# CITY OF ALBUQUERQUE

October 27, 2020

Re: **StarBucks**  
**8721 Washington NE**  
**Traffic Circulation Layout**  
Architect's Stamp 10-15-2020 (C17-D128)

### A3 ARCHITECTURAL SITE PLAN

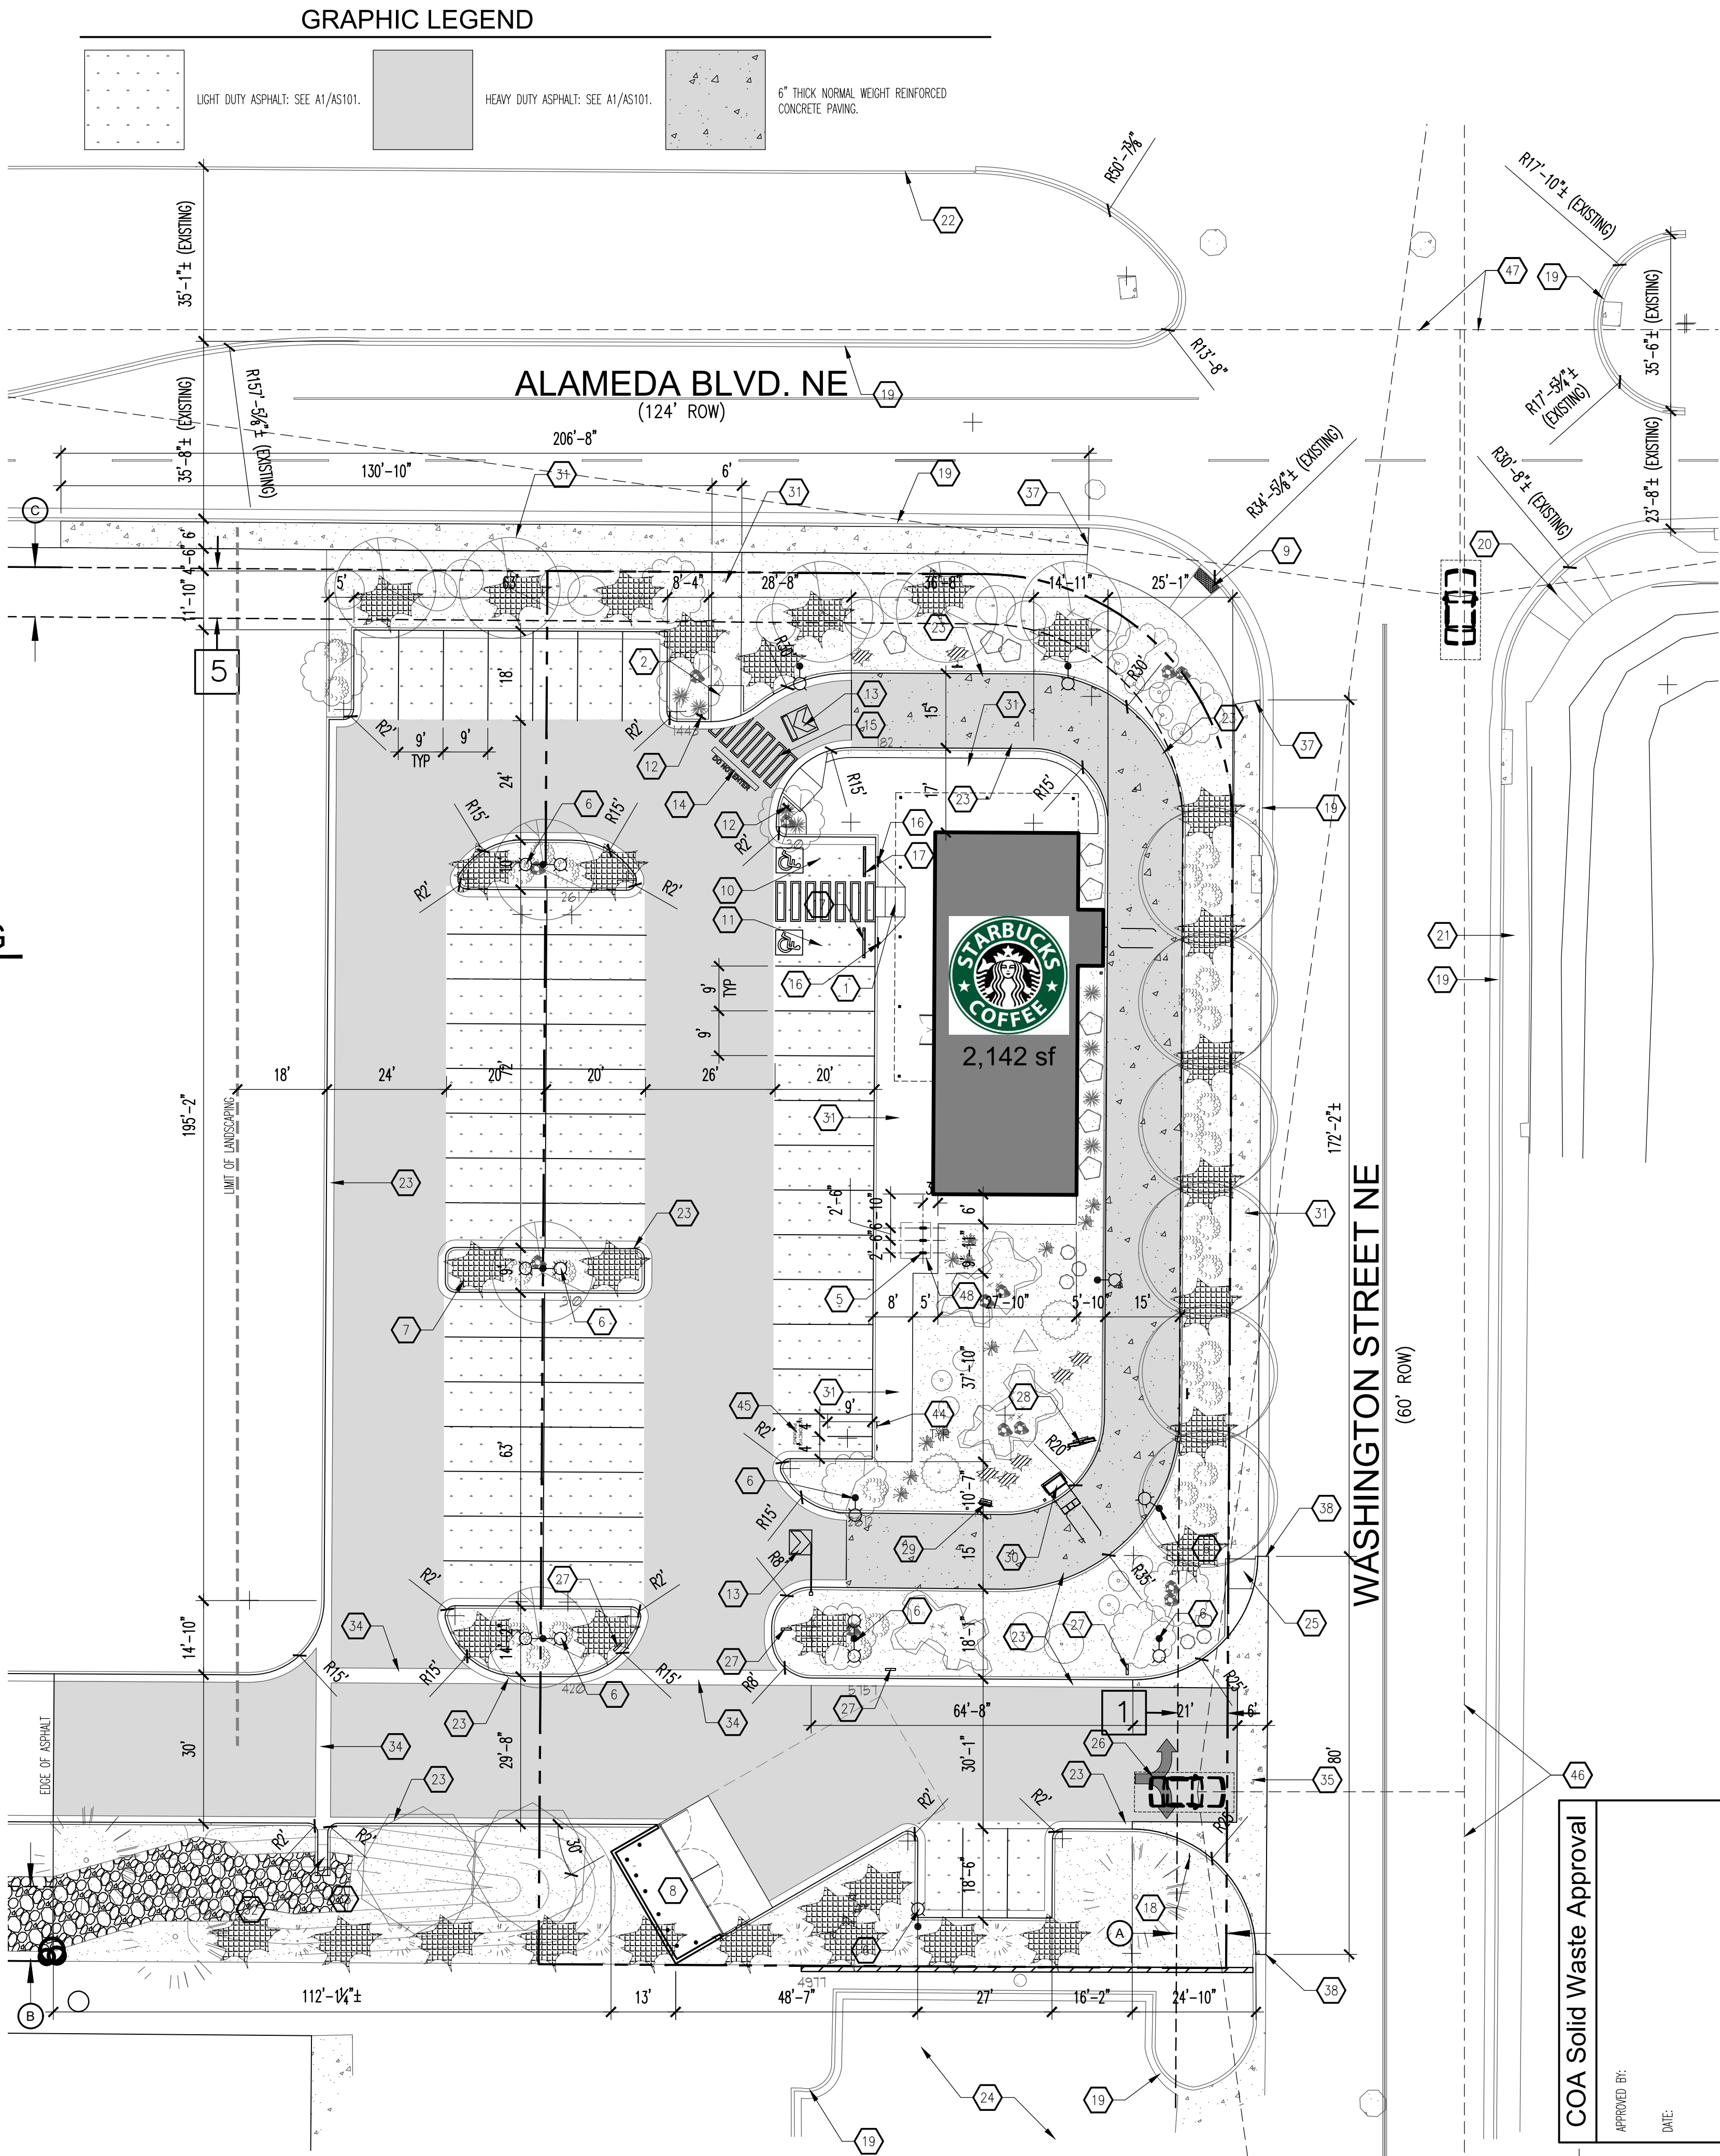
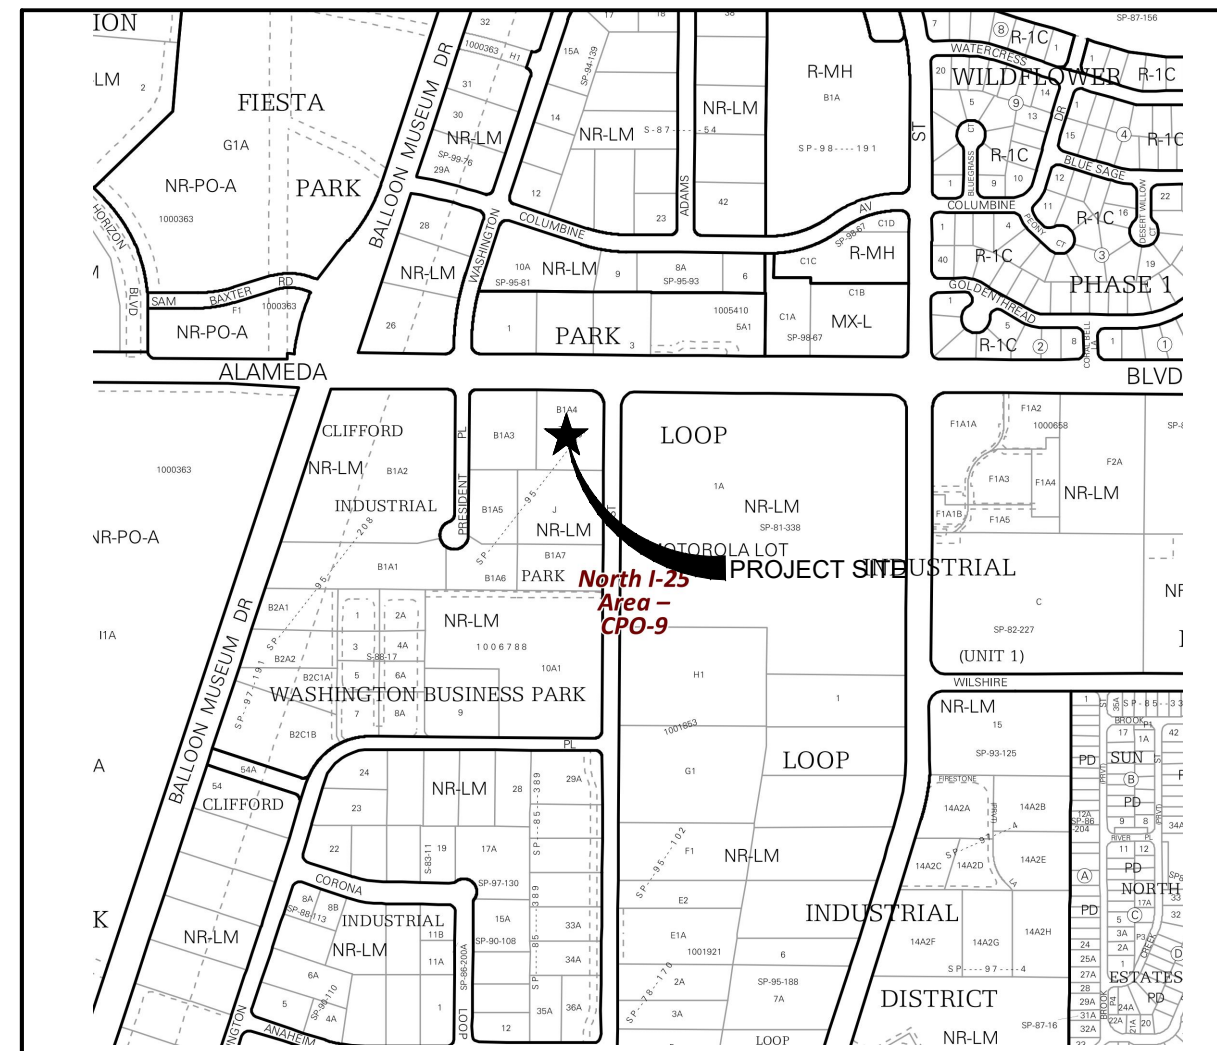
1. **Proposed Washington St. Driveway/frontage: Ramps will be needed at driveway; sidewalk/ramp will be needed at southern portion of proposed driveway (provide on keyed notes).**

2. **Please specify the City Standard Drawing Number when applicable: Sidewalk needs to be called out; COA std dwg 2430.**
3. Shared Site access: driveways that straddle property lines, or are entirely on one property but are to be used by another property, shall have an access easement. **Please include a copy of your shared access agreement with the adjacent property owner.**
